Application no: 22/02848/DISC

Location: Heyford Park, Camp Road, Upper Heyford, OX25 5HD

Transport Development Control

The issues set out below need to be addressed to ensure that the Design Code conforms to current standards

**DENSITY PLAN**

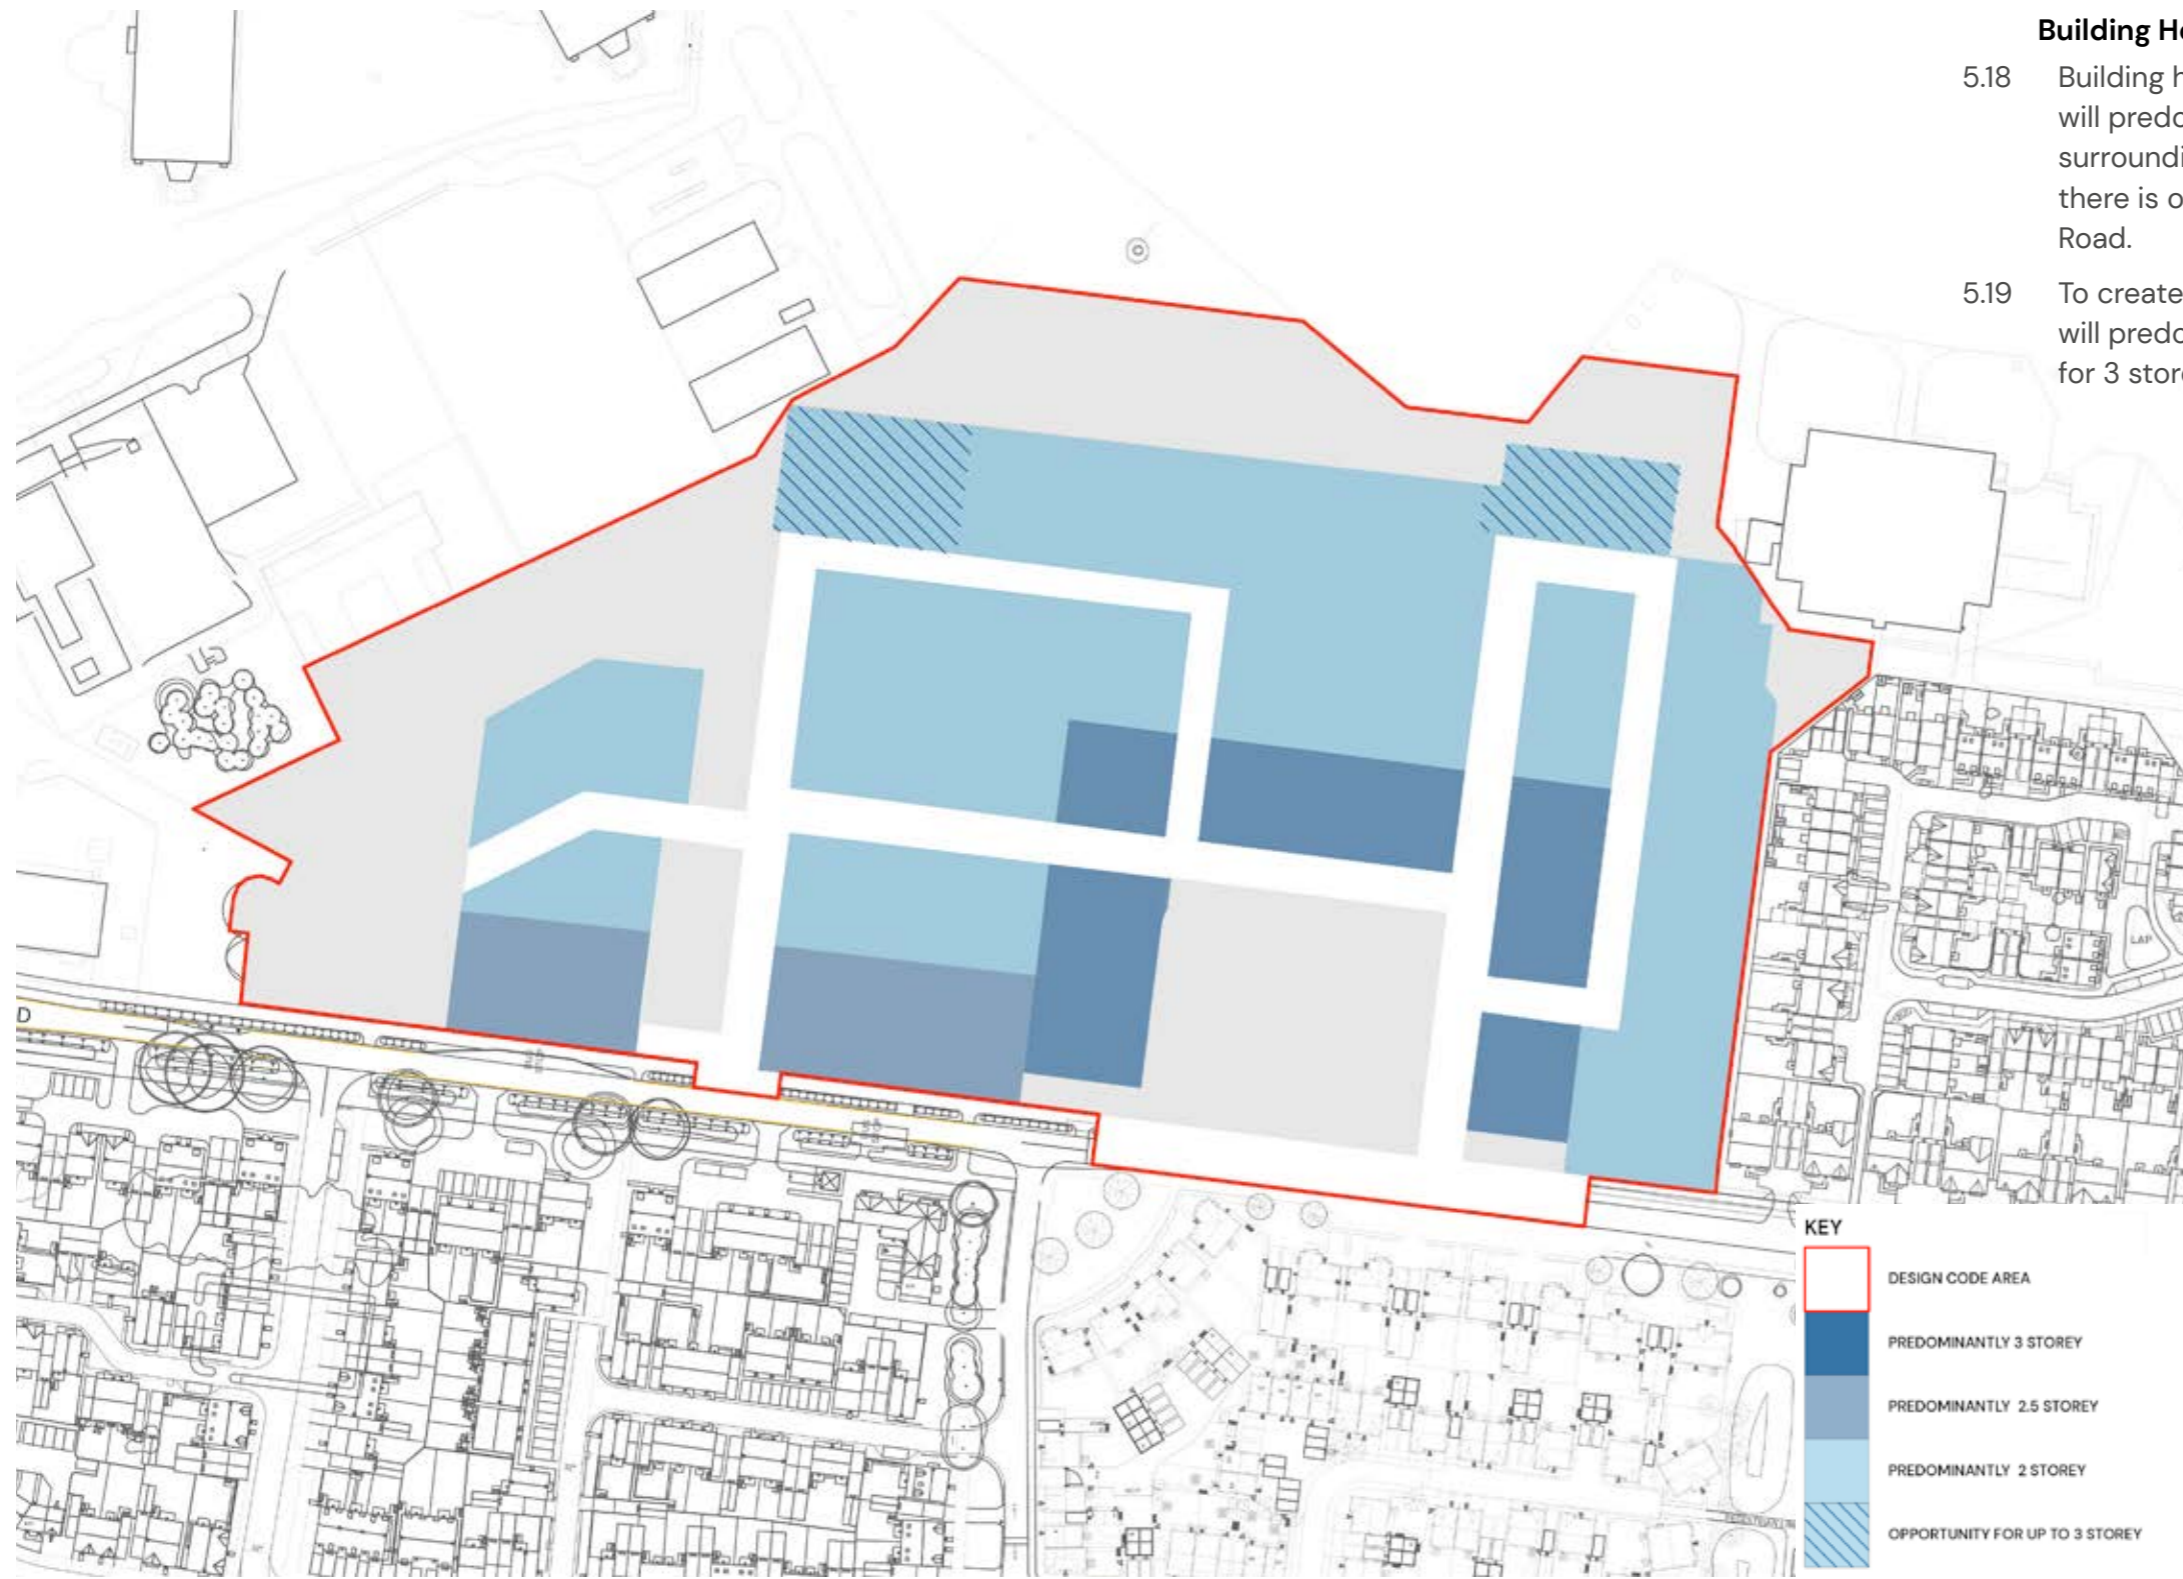
The housing density displayed on page 44 is the inverse of what OCC would recommend for new housing developments. The higher density of population should be

located at a closer proximity to the public transport links, in this case Camp Road, this is likely to improve patronage and help the bus service to become commercially viable.
